Issue Specific Hearing 1 (ISH1) General and overarching matters

Hearing Action Points

Application by Elements Green Trent Limited for an Order Granting Development Consent for the Great North Road Solar and Biodiversity Park (EN010162).

Actions arising from **ISH1** held on **Wednesday 26 November and Thursday 27 November 2025**

Great North Road Solar and Biodiversity Park Environmental Statement

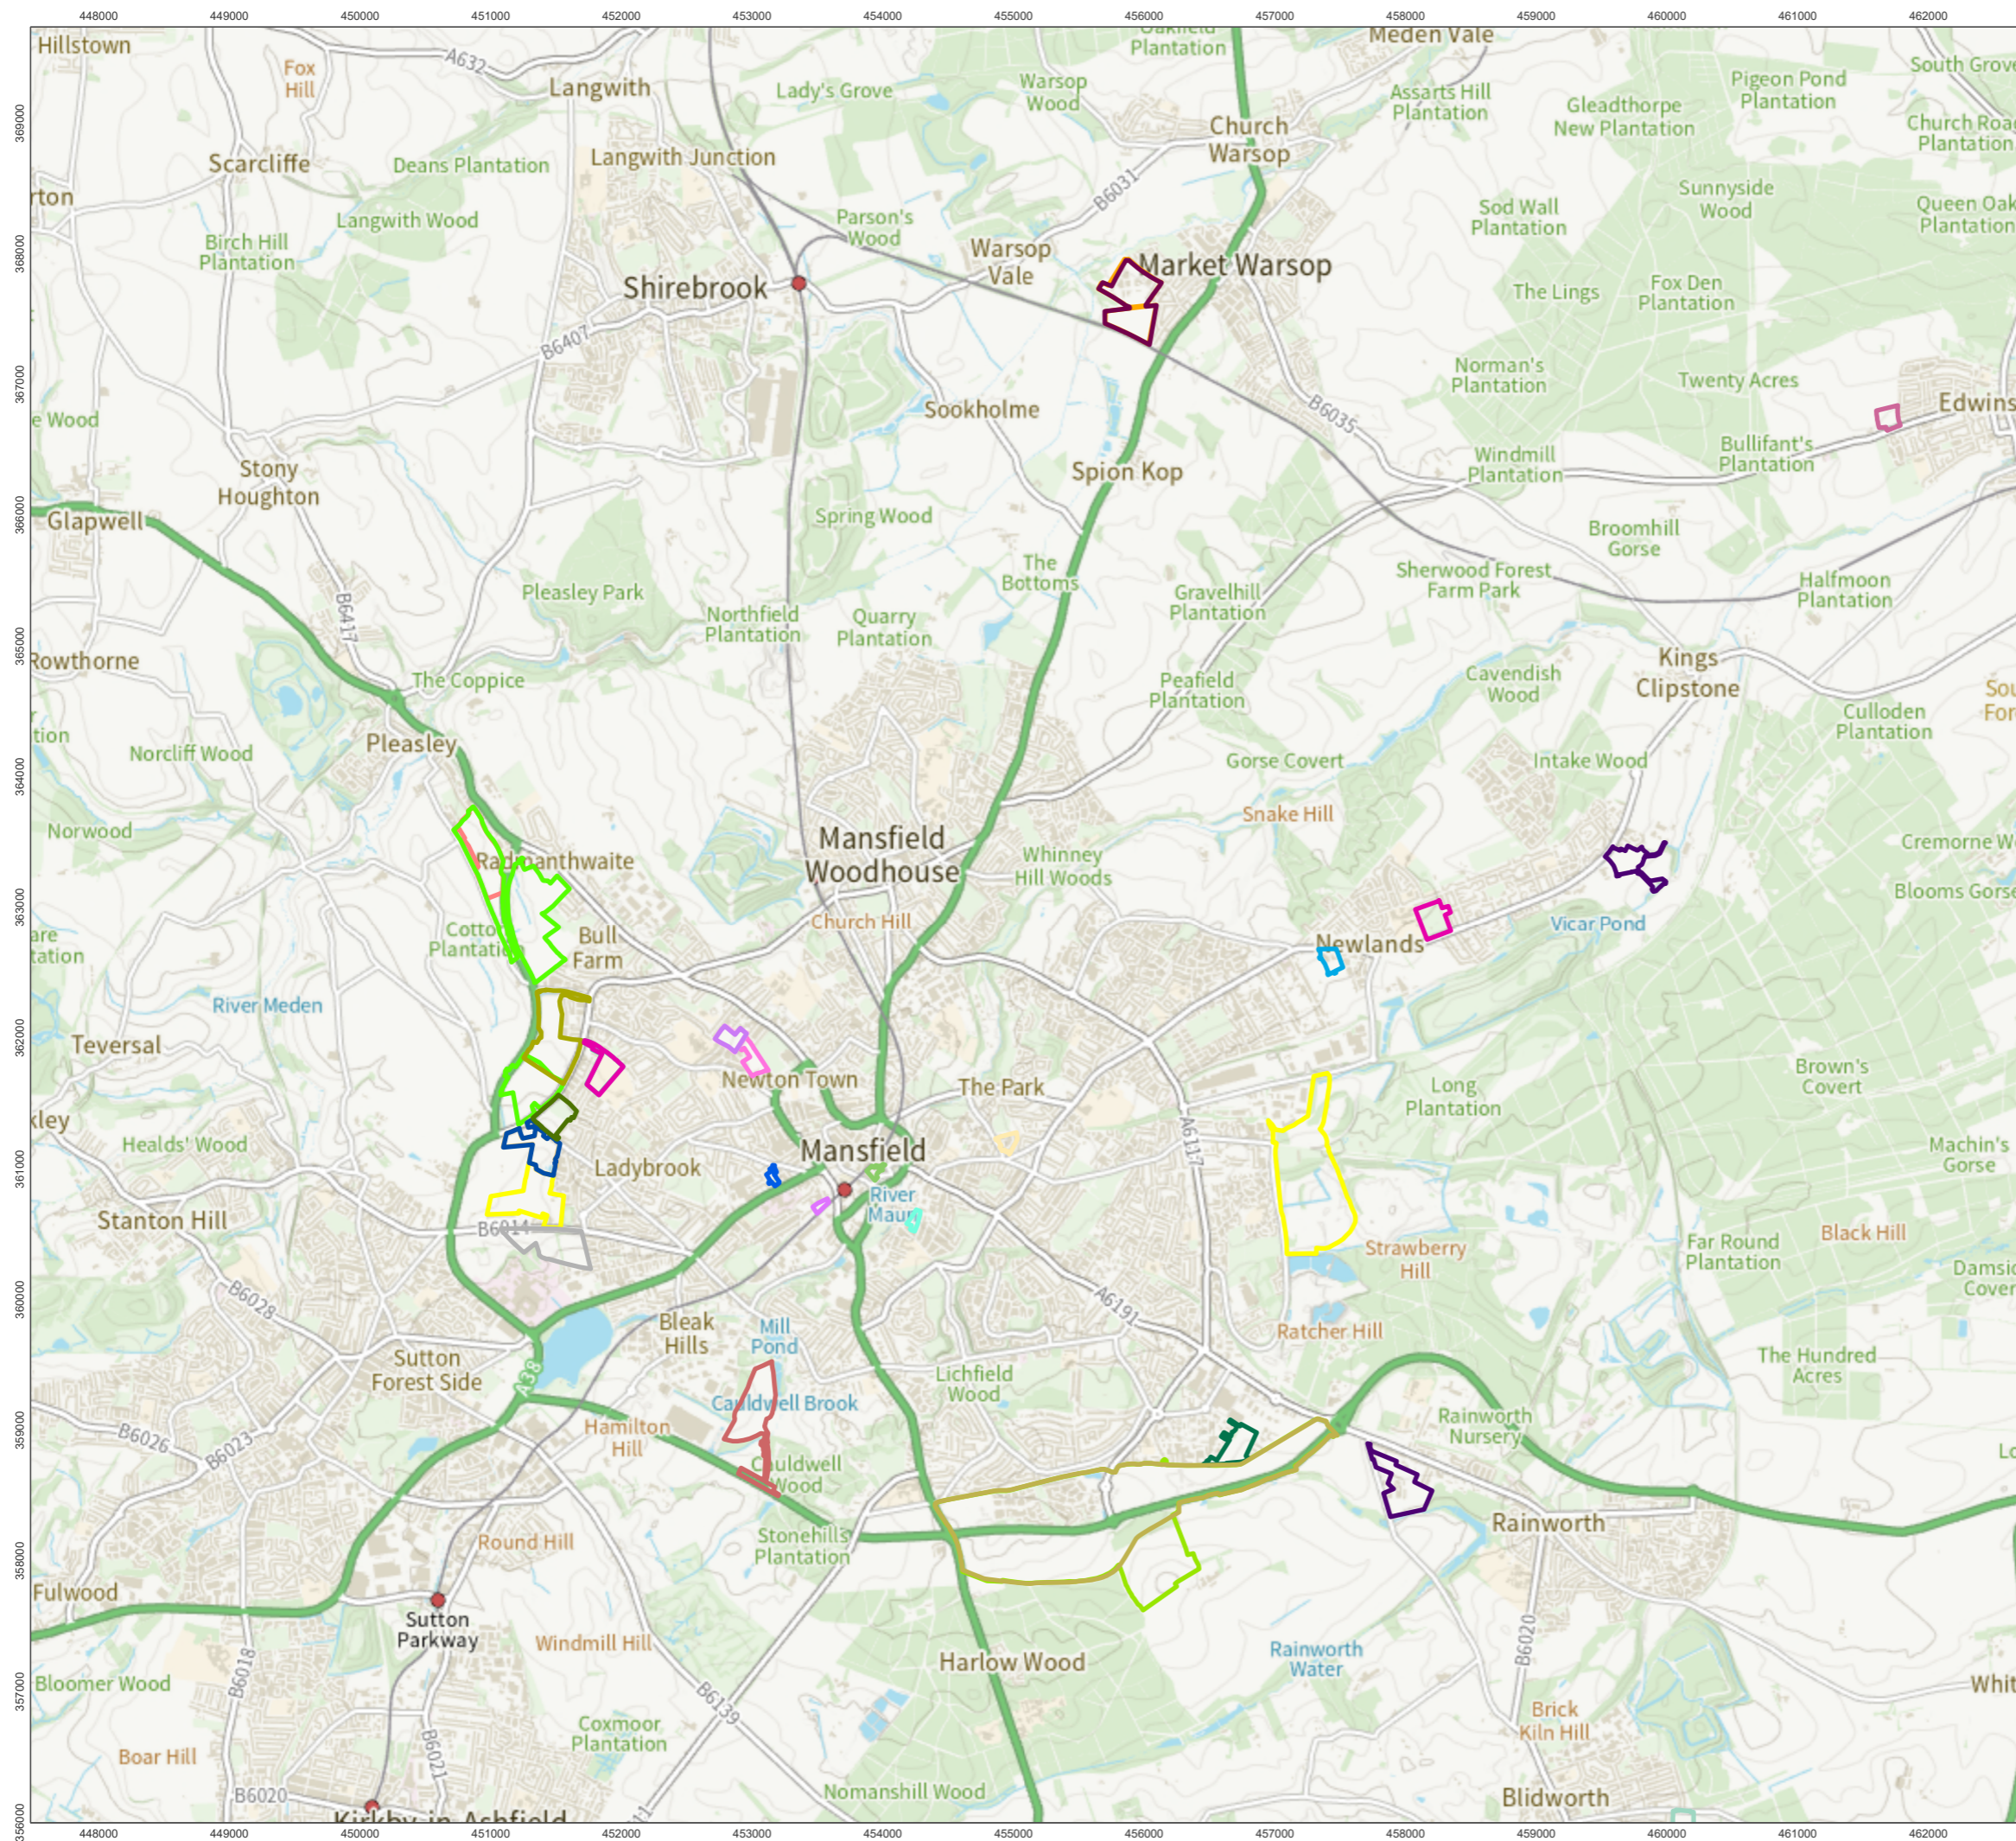
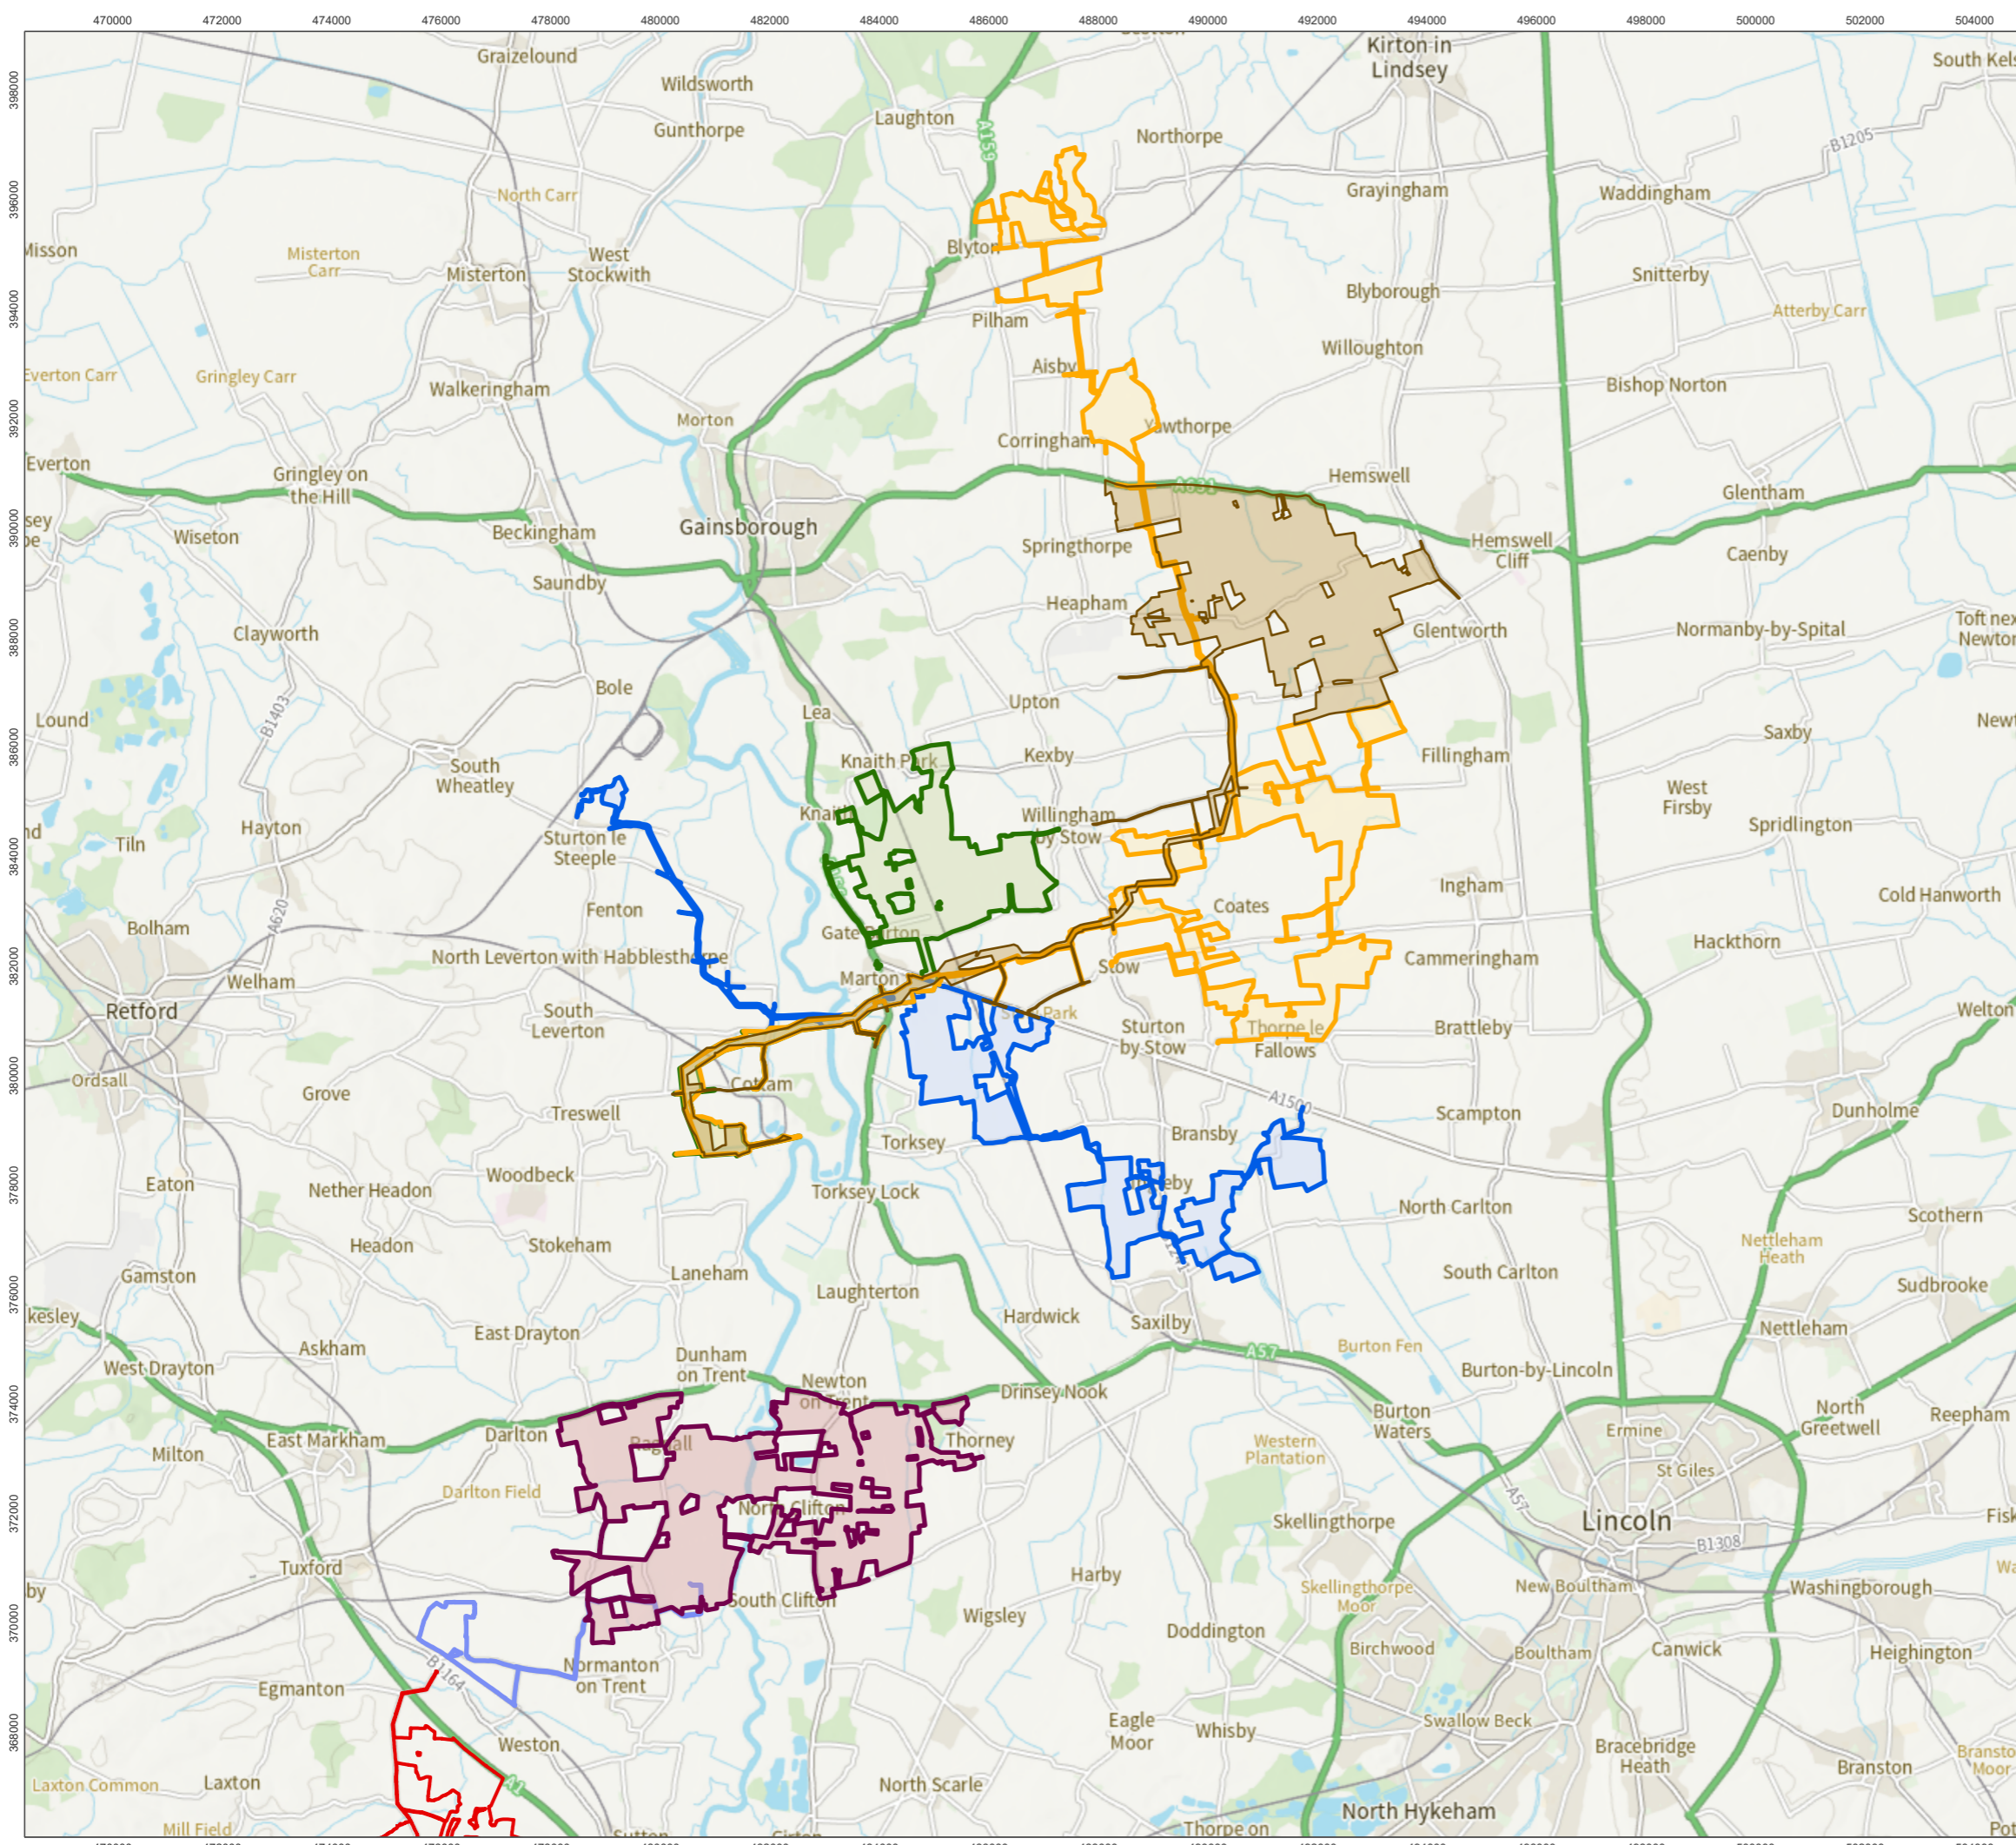
17.	Please review Technical Appendix A2.1 – Cumulative Assessment Stages 1 and 2 [APP-191] at Figure A2.1.1 (a-d), noting that there is some confusion as projects are not listed by names but rather their reference numbers, which are not all up to date (eg the Steeple Renewables DCO application appears to have its scoping report reference)	Applicant	D1
